I am writing to object to the modified proposal at
13 FERN CLOSE SOOTHILL LANE BATLEY WF17 6HD
APPLICATION NUMBER 2019/93650

PROPOSED REAR ELEVATION

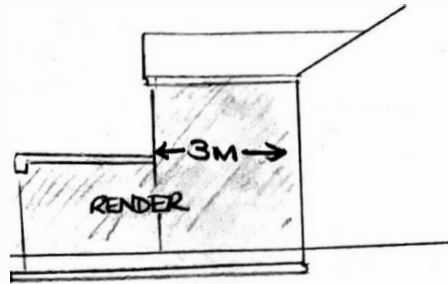
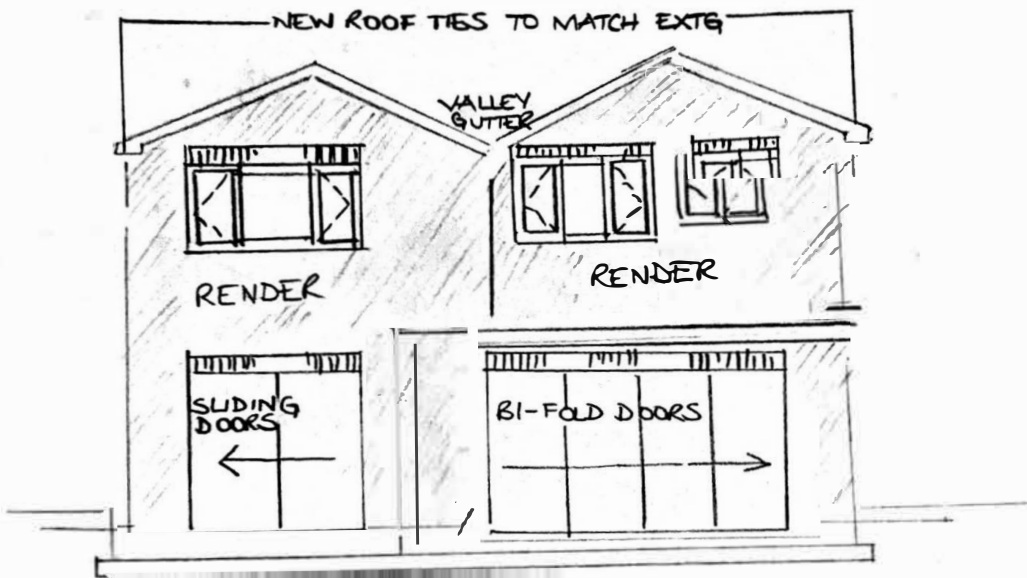
This application was rejected last year and as far as I can see nothing has changed. They have built the single storey L shape extension which will have a second storey joined on to the original house but now are wanting a second storey built on to an existing extension which will encroach on our view and also on plans it says original bricks to match original house at the rear but the side have a double row of Breeze Blocks so will that be rendered?? which will look an eyesore. The outer blocks is in line with the existing brickwork. The company who took the photos took them at a suitable angle to make the space wider. They did not take one from front to rear to show how the boundary comes in at an angle and to show a ~~the~~ mature Beech tree approx 8-9 metres high.
